Town & Country Planning Act 1990 (as amended)
Town and Country Planning (Development Management Procedure) (England) Order 2015
Approval of details reserved by condition imposed under ref LU/47/11/ relating to Condition Nos 10
surface water drainage scheme, 11 future access to & maintenance of any watercourse or culvert,
12 discharge of any flows to watercourse, 13 foul water drainage system.
Land North of Toddington Lane Littlehampton,,

Arun District Council have decided to **REFUSE details reserved by condition for the following reasons:**

The information submitted regarding Condition 12 imposed on planning permission LU/47/11: relating to the discharge of any flows to watercourses, or the culverting, diversion, infilling or obstruction of any watercourse on Parcel C1 and parts of Parcels B2, B4; and C2 (LU/121/17/RES) and constitutes Phase 2 of development at the North Littlehampton Strategic Development Area (SDA), is refused and the condition is not discharged as:

Figure 3.1 Existing Lagoon and Ditch (in green) to be filled in

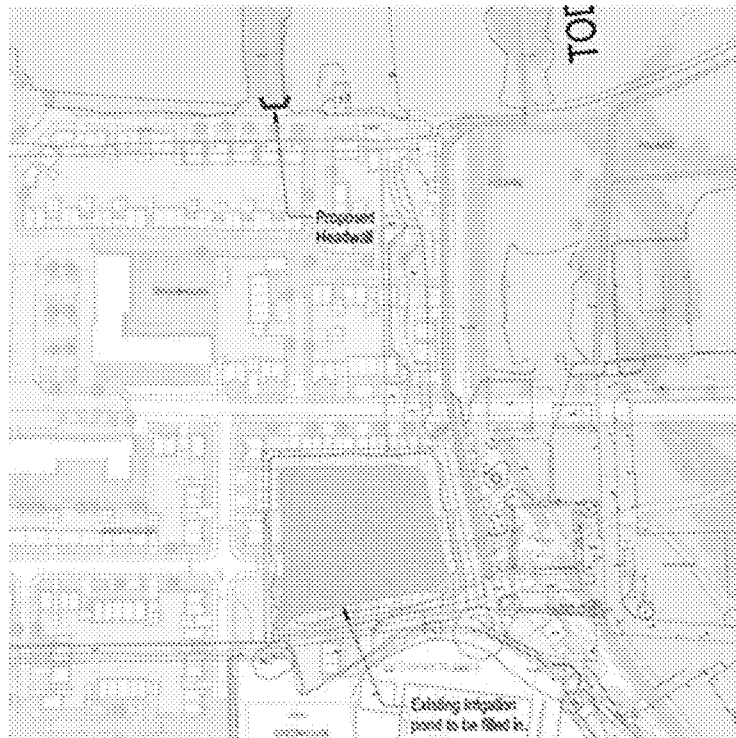
* The proposal includes infilling an IDB ditch on site, consent will be required from the Environment Agency;
